City of Albuquerque  
Stormwater Construction Site  
Inspection Report

Project Name and Location	O'Reilly Auto Parts 8001 Ventura St NE		
Site Contact Name & Agency	Steve Haglen Hutton Construction	ESC File No. NPDES ID No.	020 EMI C NMR 1001 EG
Date of Inspection	10-11-18	Start/End Time	9:30/10:00
COA Inspector Name	Curtis Cherne, Stormwater Quality		
Describe Present Phase of Construction	Steel erected

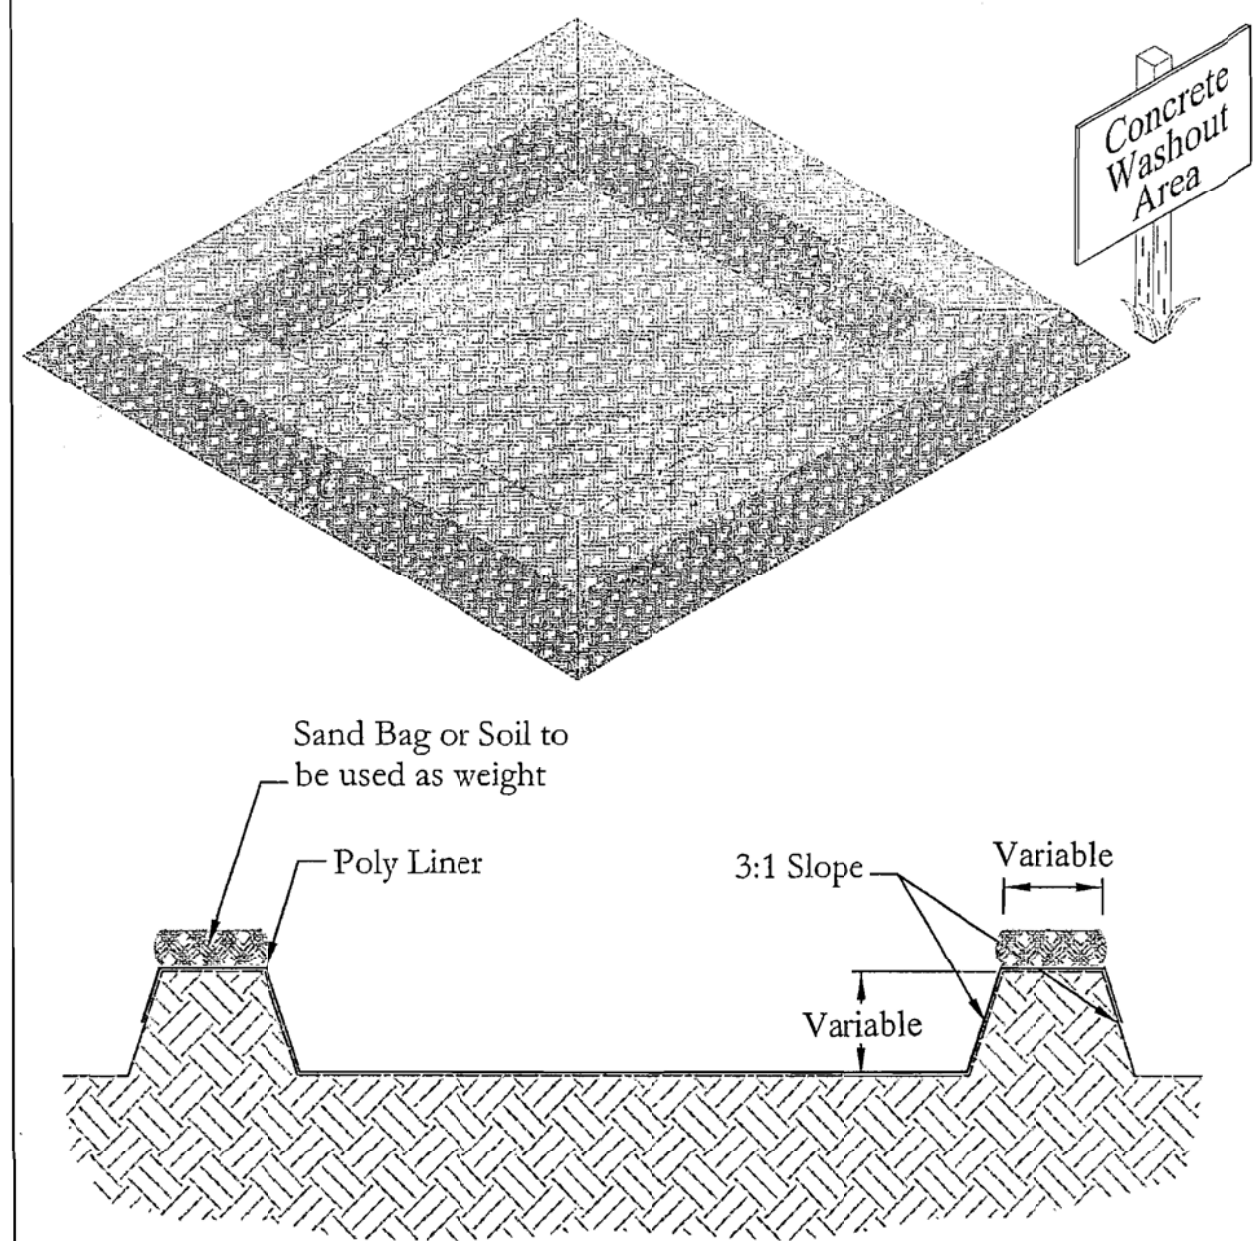
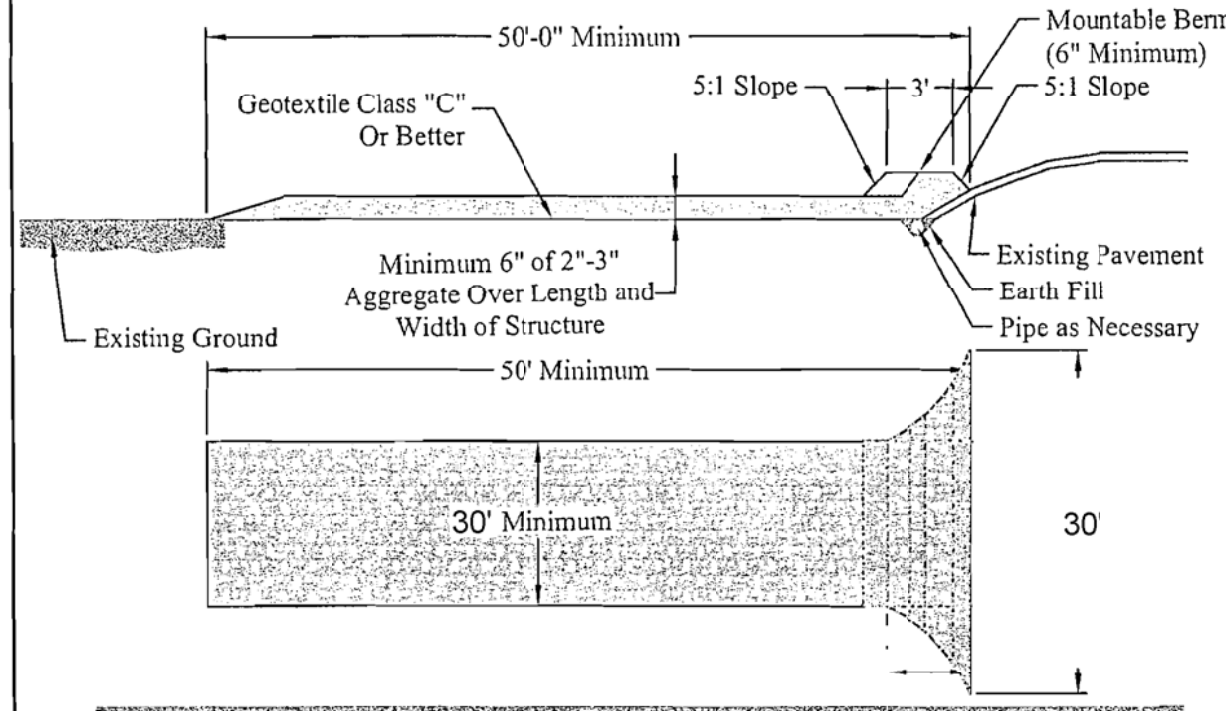
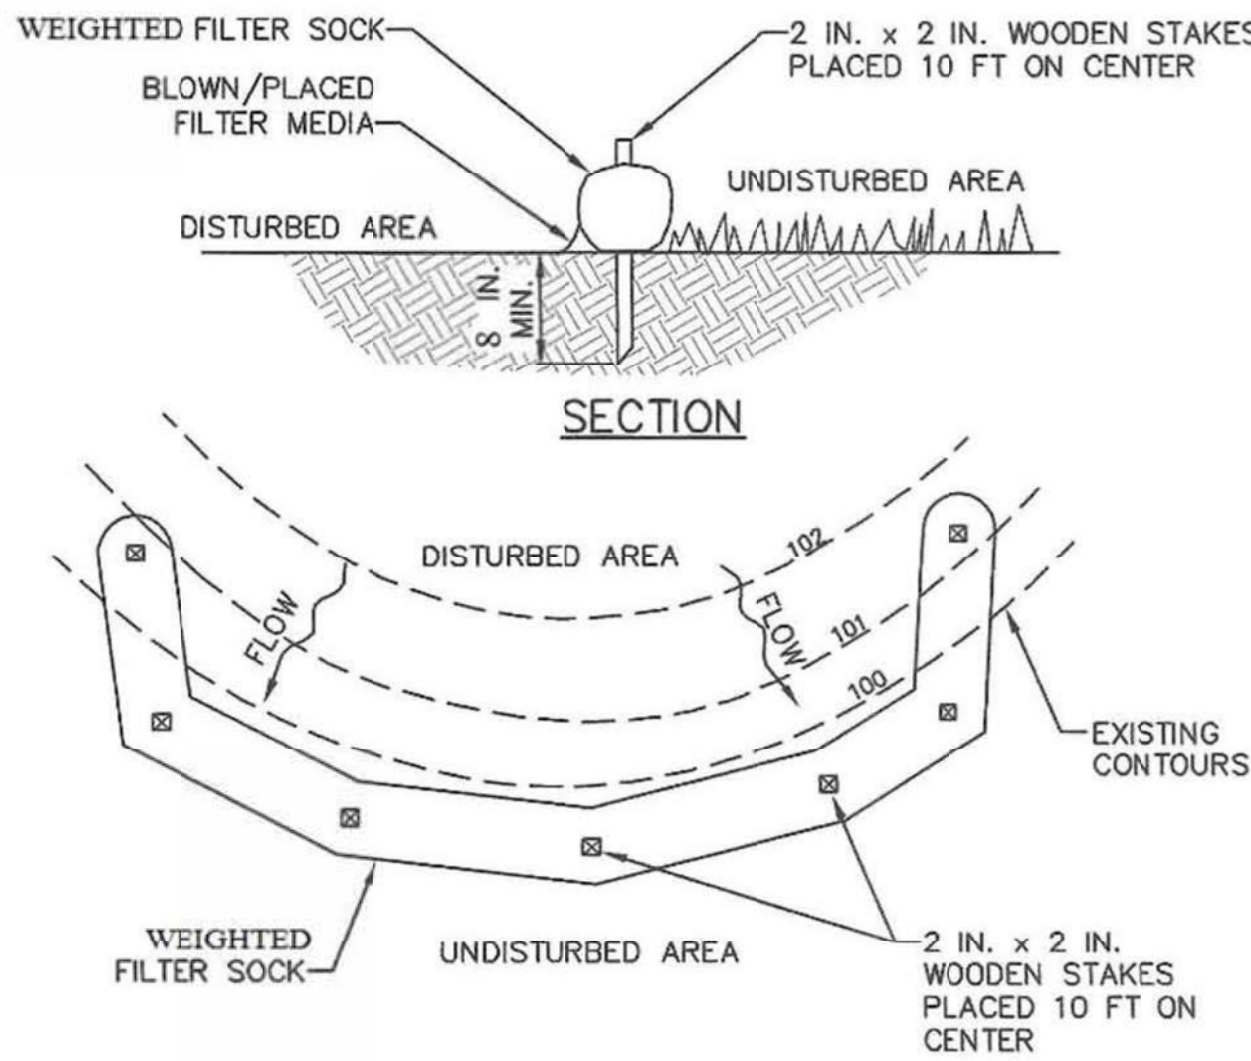
2.2.1	Provide and maintain Natural buffer when Waters of the US < 50 ft	• Yes • No	• Yes • No	
2.2.3	Sediment control along any perimeter	<input checked="" type="radio"/> Yes • No	• Yes • No	sediment in South-NE

2.2.4	Minimize sediment track-out	• Yes • No	<input checked="" type="radio"/> Yes • No	no vehicle tracking control
2.2.5	Manage stockpiles	• Yes • No	• Yes • No

2.3.4	Washing Applicators used for paint, stucco, concrete, etc.	<input checked="" type="radio"/> Yes • No	• Yes • No	numerous washouts west of 616g
2.3.4	Washing Applicators used for paint, stucco, concrete, etc.	• Yes • No	<input checked="" type="radio"/> Yes • No	no wash-out facility

Notes: (City Inspector Use) For inspection items with numerous rows, additional/unused rows may be left blank.  
(1) Maintenance is to be complete by the end of the next business day.  
(2) Corrective Actions are to be complete within 7 days.
